**Application by Highways England for the A1 in Northumberland: Morpeth to Ellingham  
The Examining Authority's written questions and requests for information (ExQ2)  
Issued on 19 March 2021.**

**Responses are due by Deadline 5: 1 April 2021.**

**Trees to be Removed and Replaced at Coronation Avenue  
WQ LV.1.8**

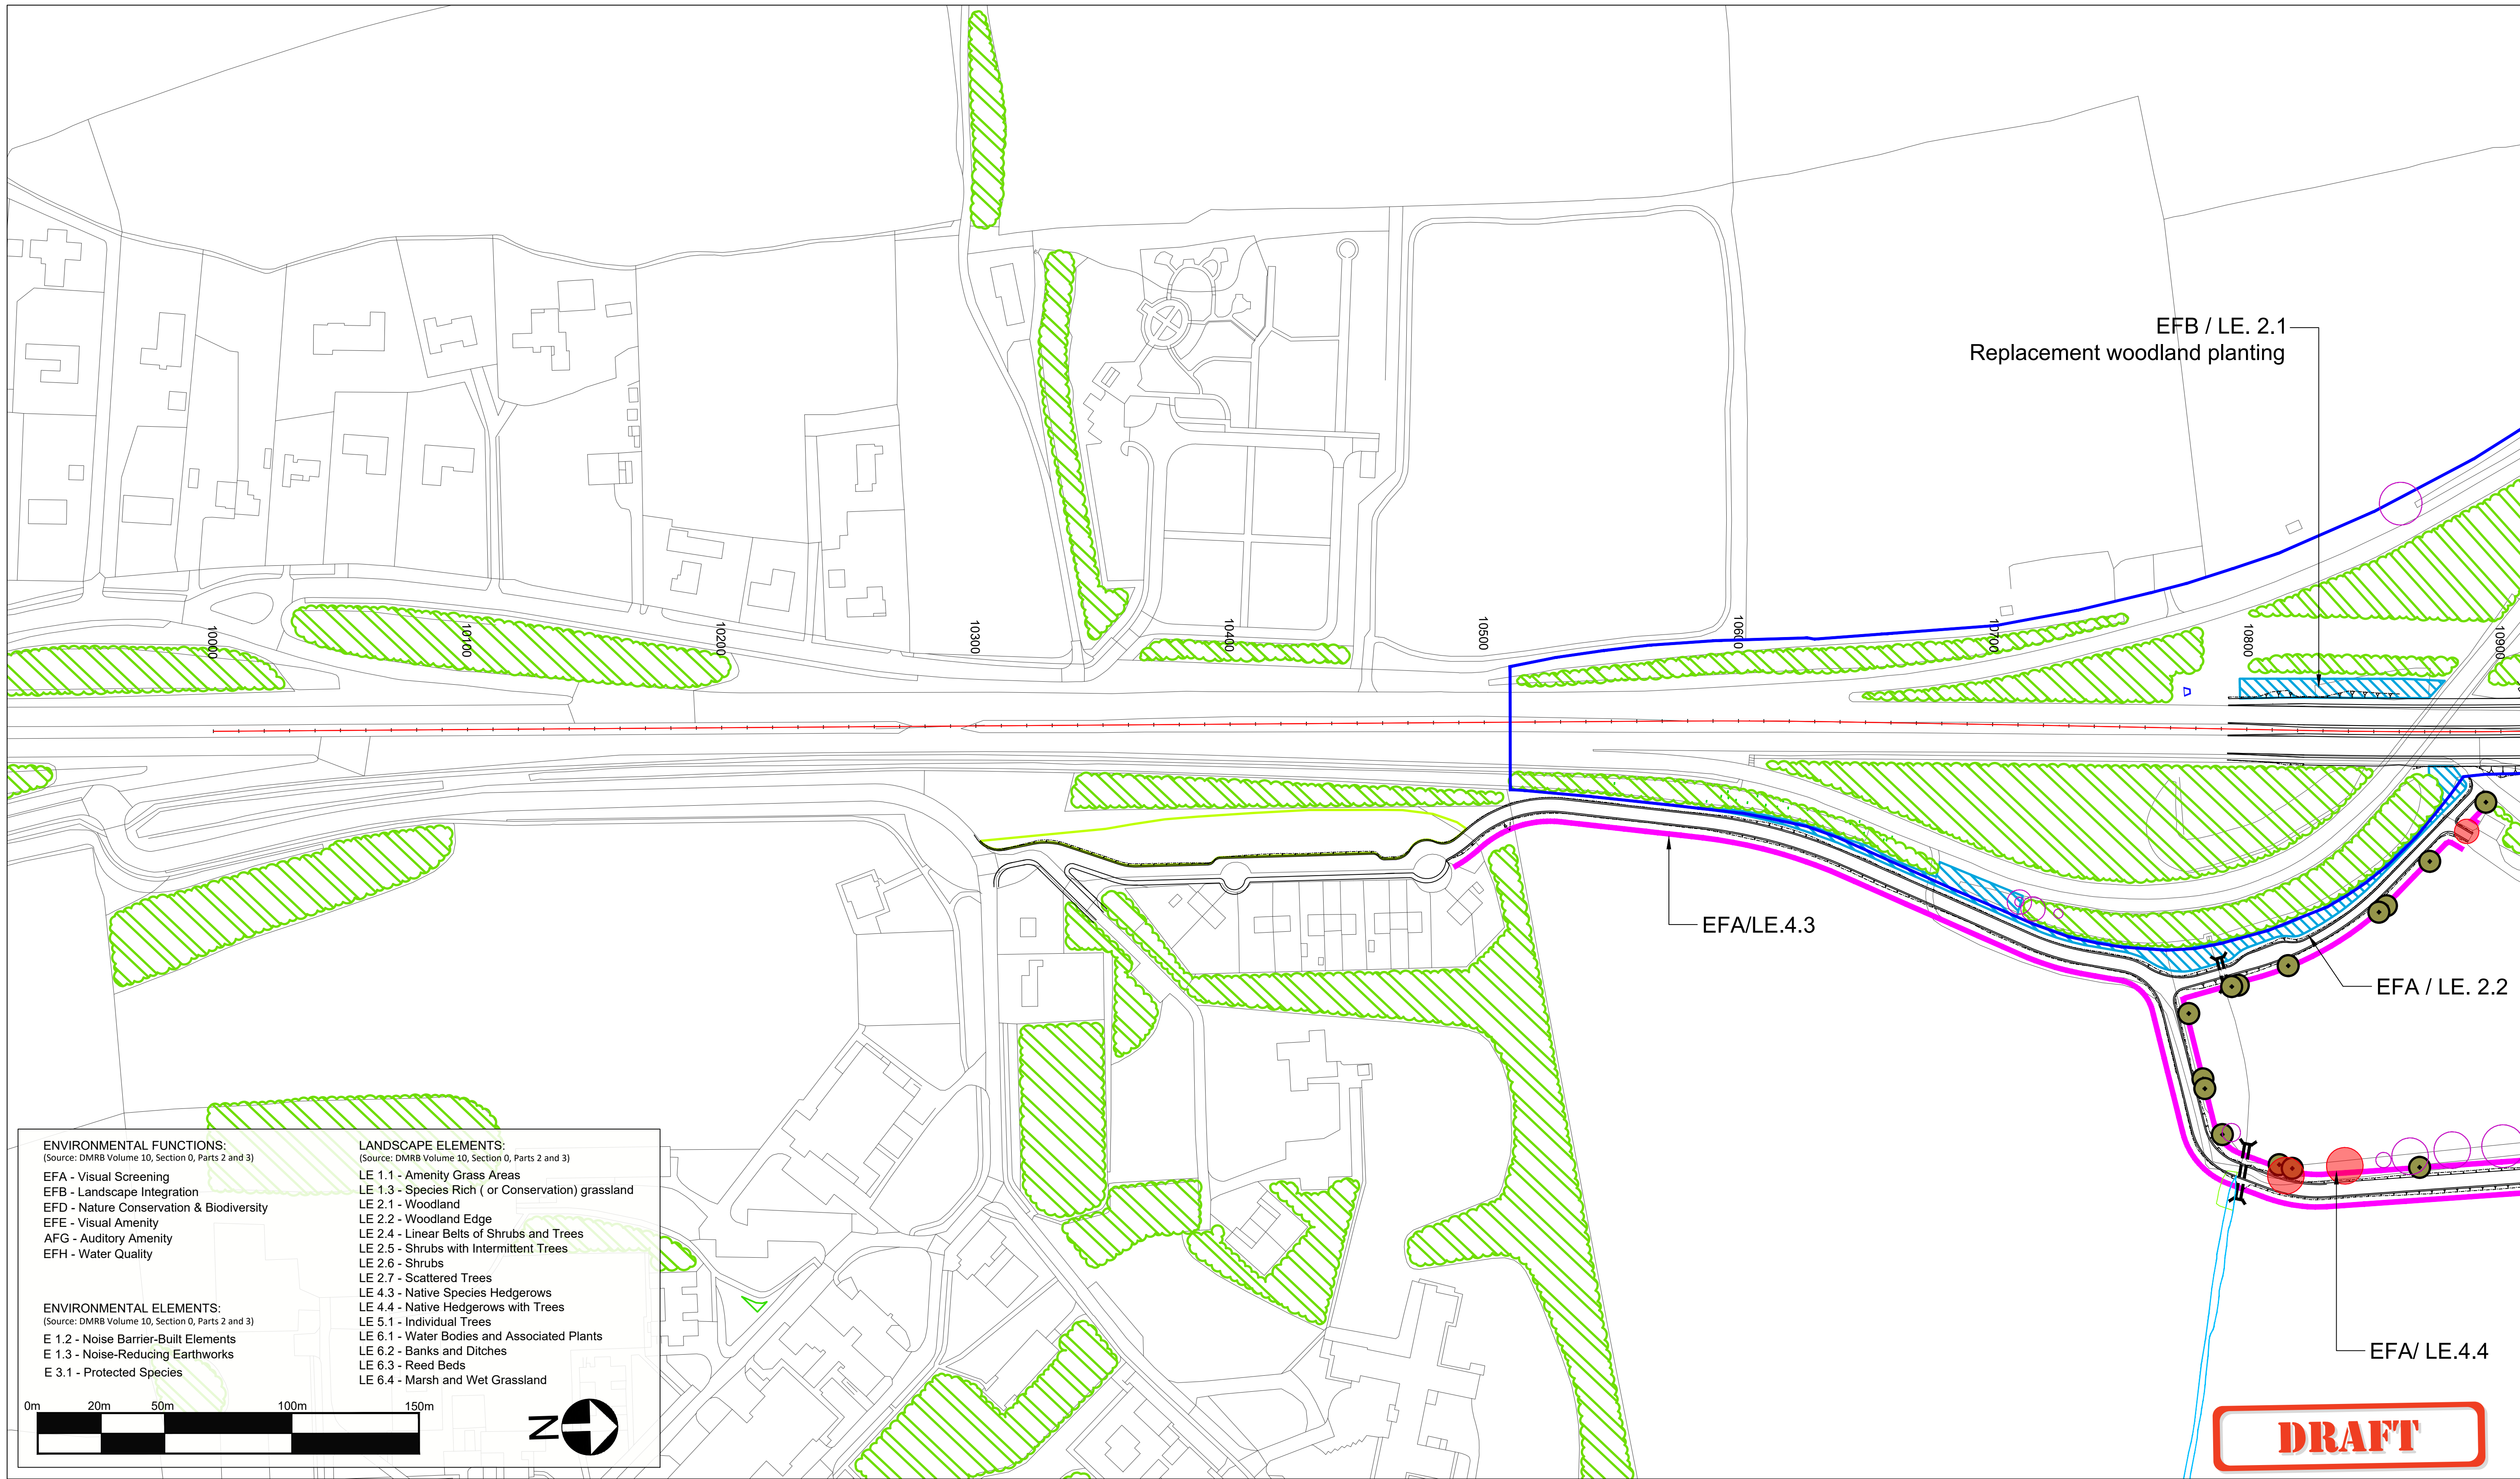
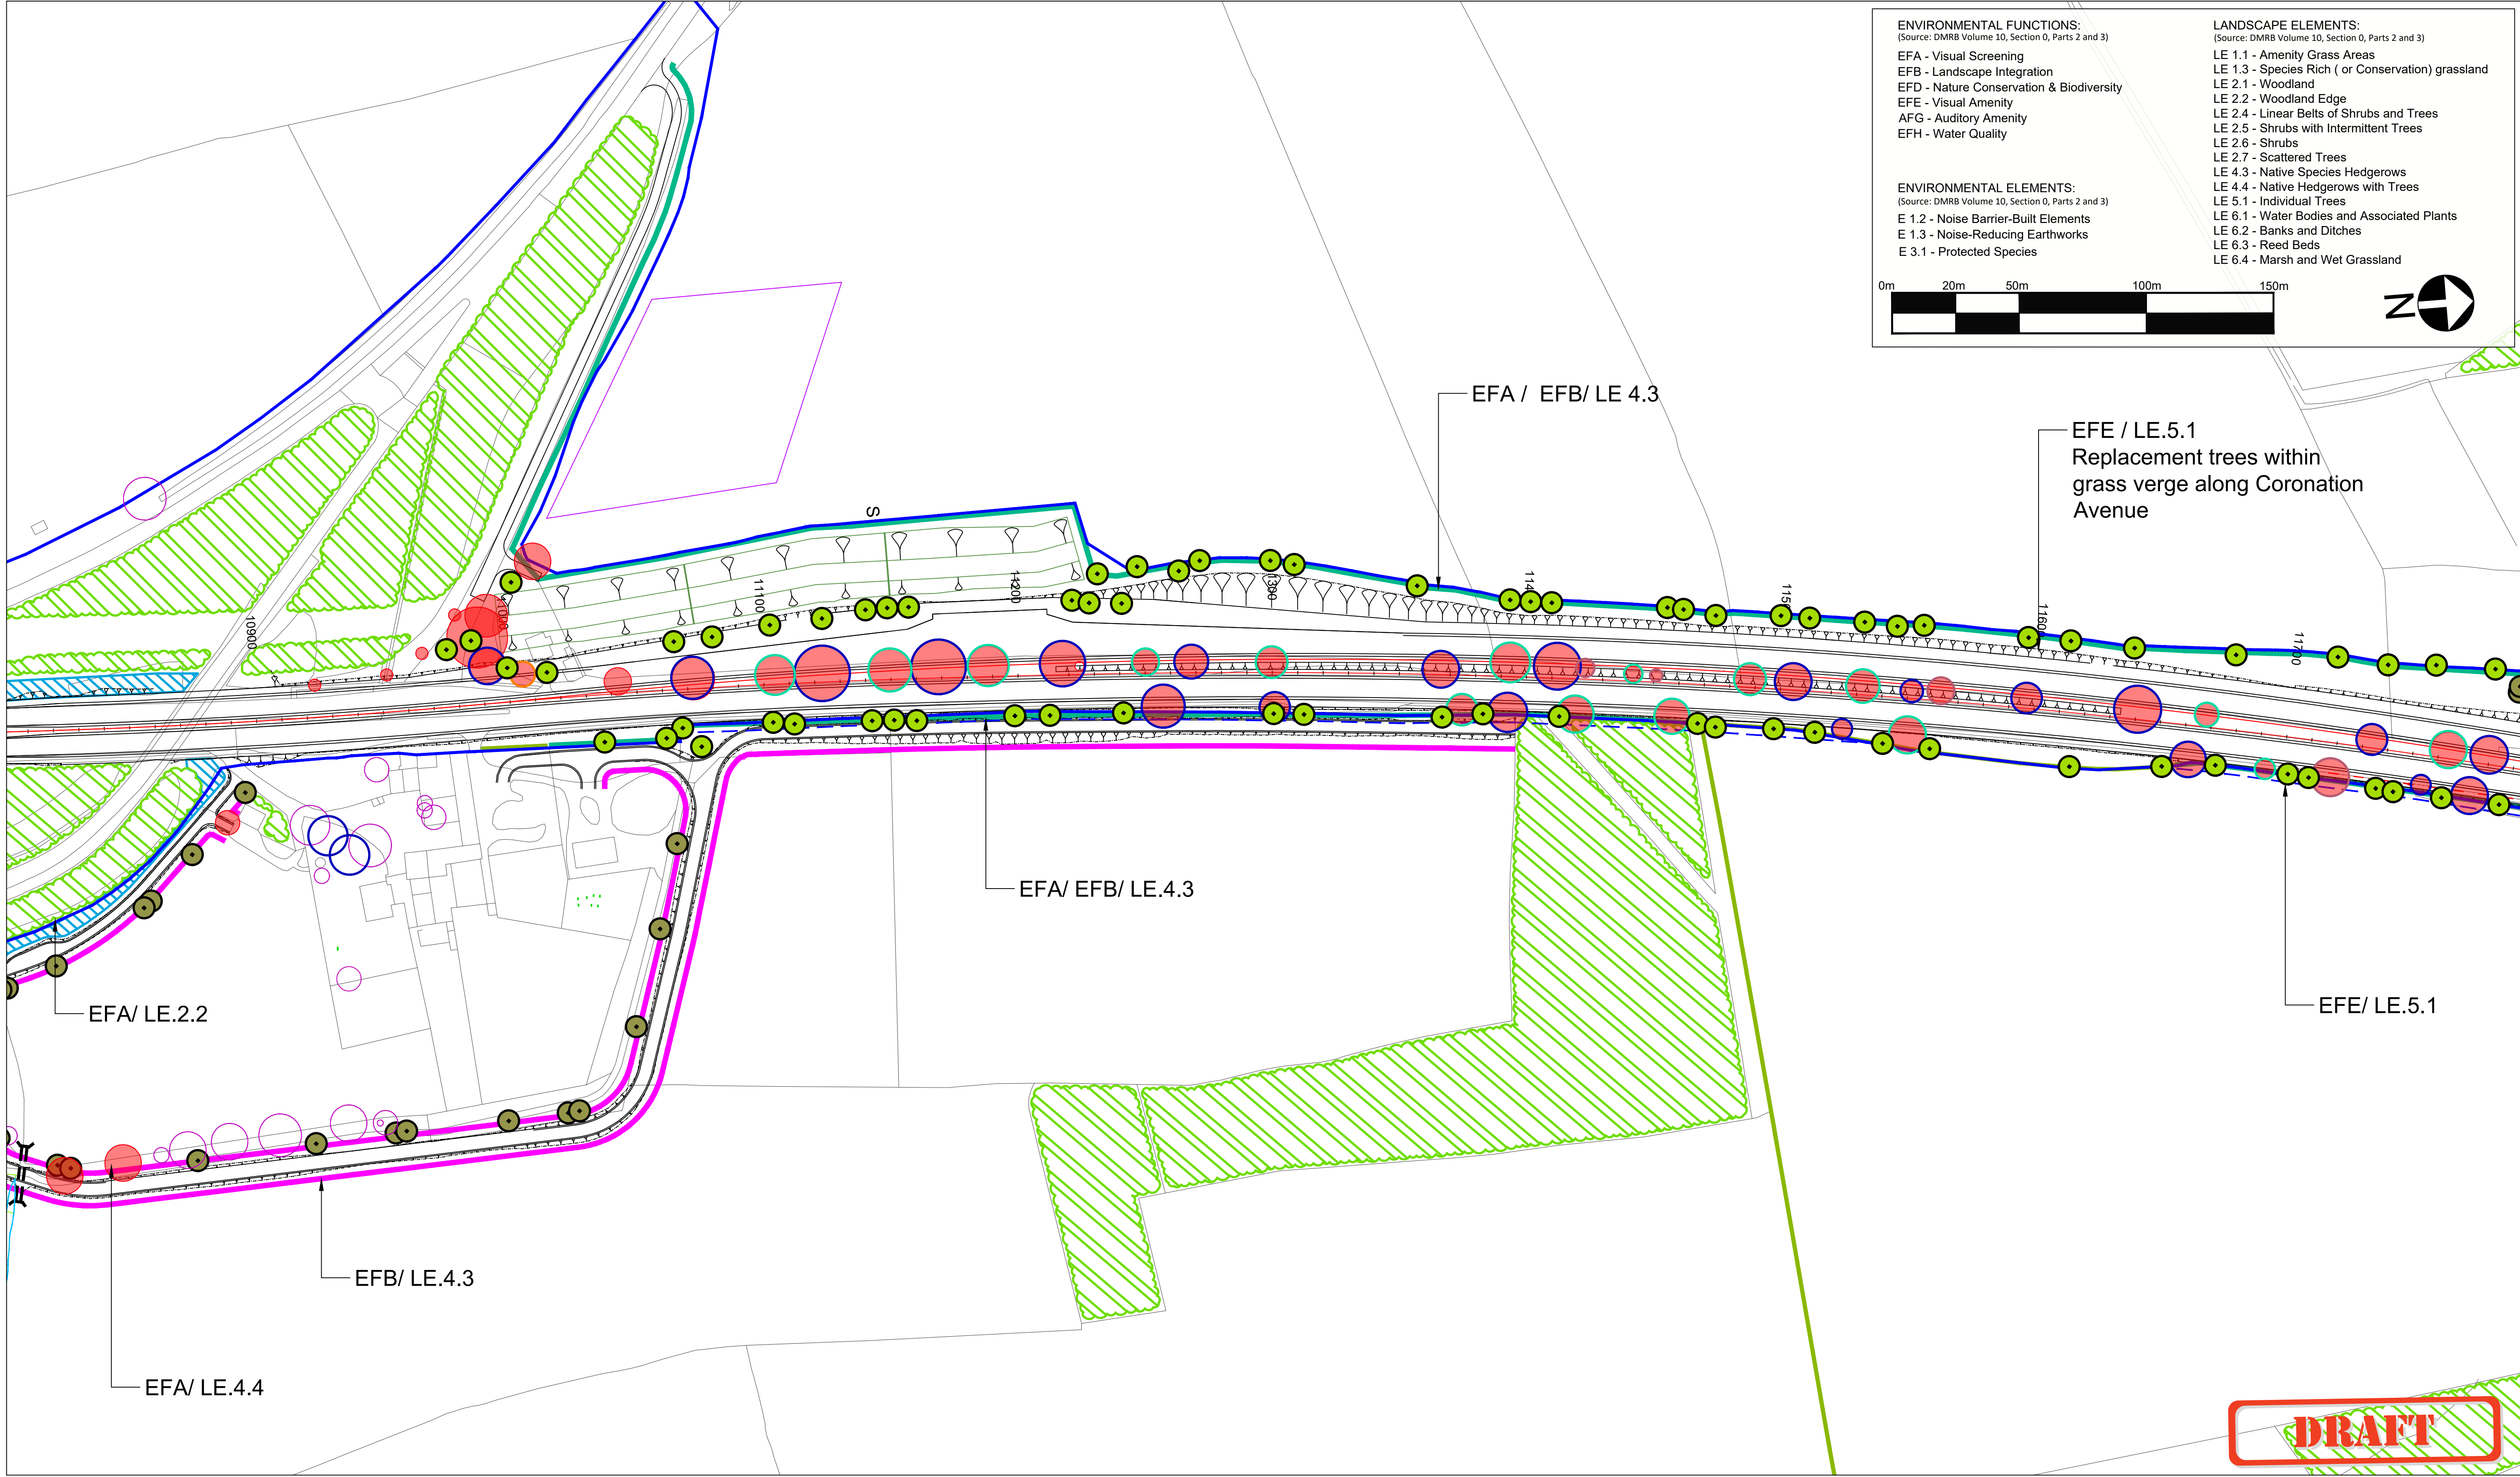
LV.2.2	Applicant IPs	The plans which form Appendix LV.2 Trees to be Removed and Replaced at Coronation Avenue WQ LV.1.8 [REP1-044] are annotated 'Draft'. The Applicant is asked to explain how this relates to the requirement in R5(3) of the dDCO for the landscaping scheme to include a strategy for the replacement of trees which are to be removed at Coronation Avenue? IPs are asked to comment on the proposals for Coronation Avenue.
